Our Ref: BN/38/18/L

Application for Listed Building Consent

Development Listed building consent for an annexe extension ancillary to the main dwelling.
Location Parsonage Farm House Lake Lane Barnham

Proposed Roof Plan

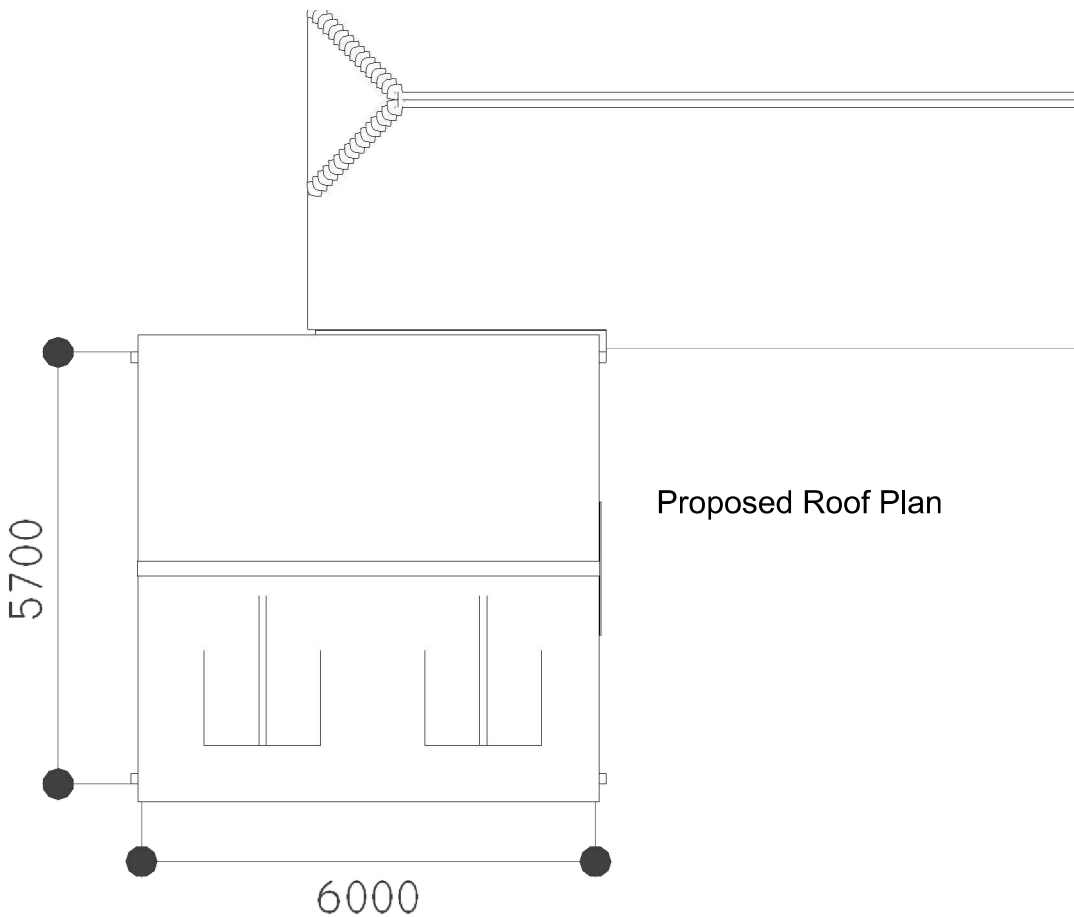
Also, because the dormer windows are in the roof, a proposed roof plan showing the windows in the roof would get over this problem.

Proposed First Floor

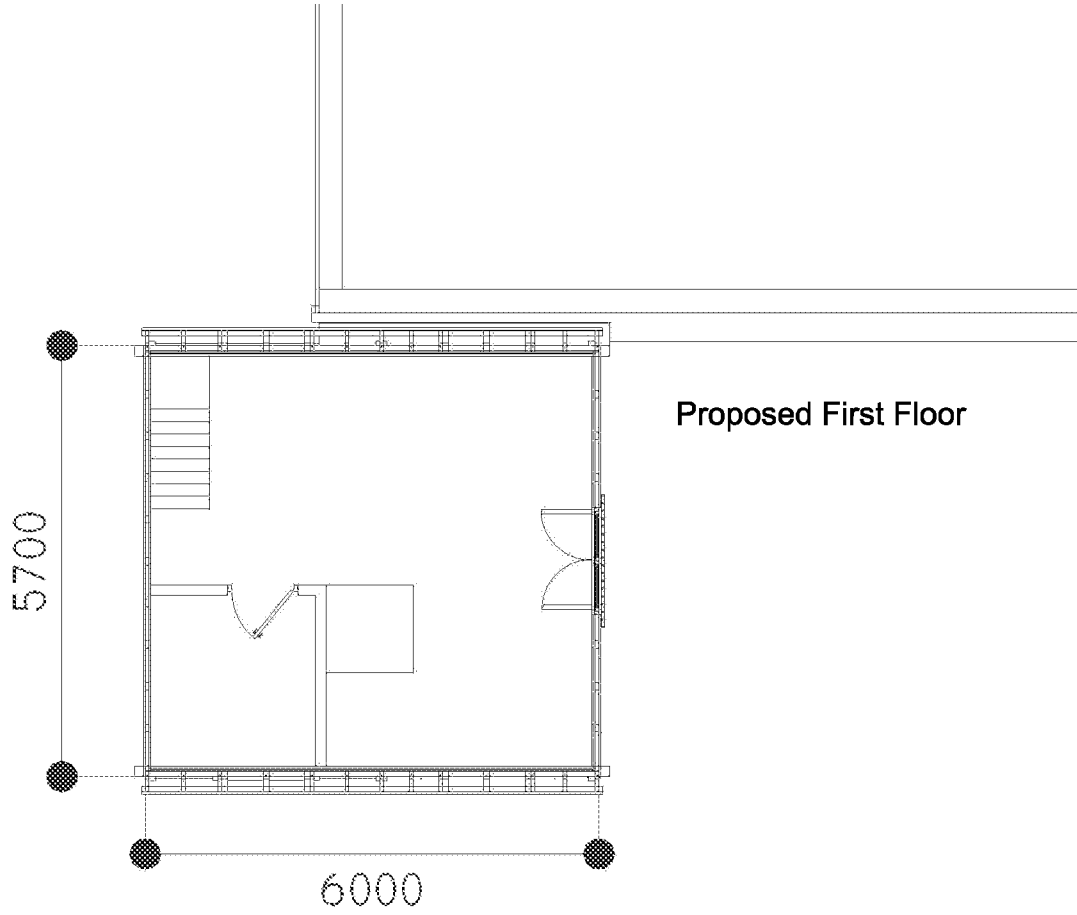
I understand that the windows may be difficult to see because of the oak weather boarding, but the existing and proposed ground floor plans and the proposed first floor plans still need to show the openings to coincide with the proposed floor plans. You may want to show the openings in a different colour to make it clear.

Proposed

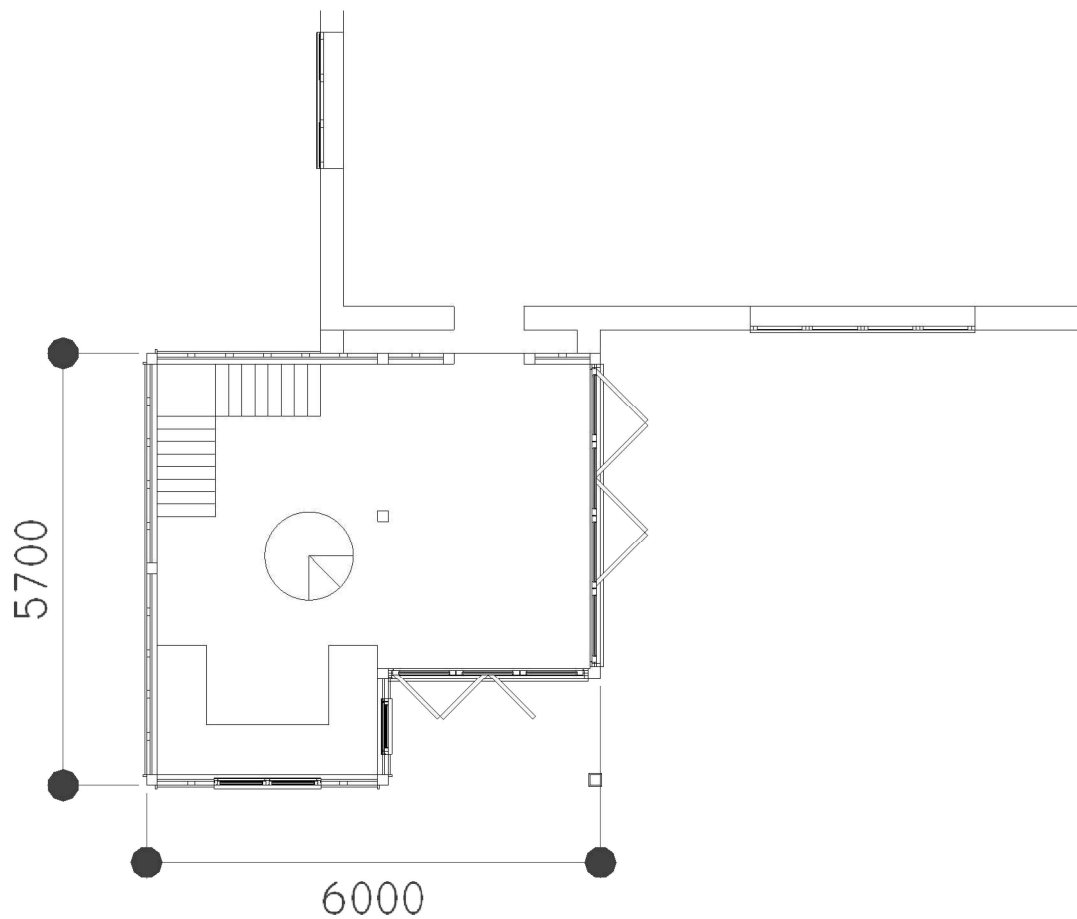
The south west and south east elevations and floor plan do not accord. Please amend accordingly.
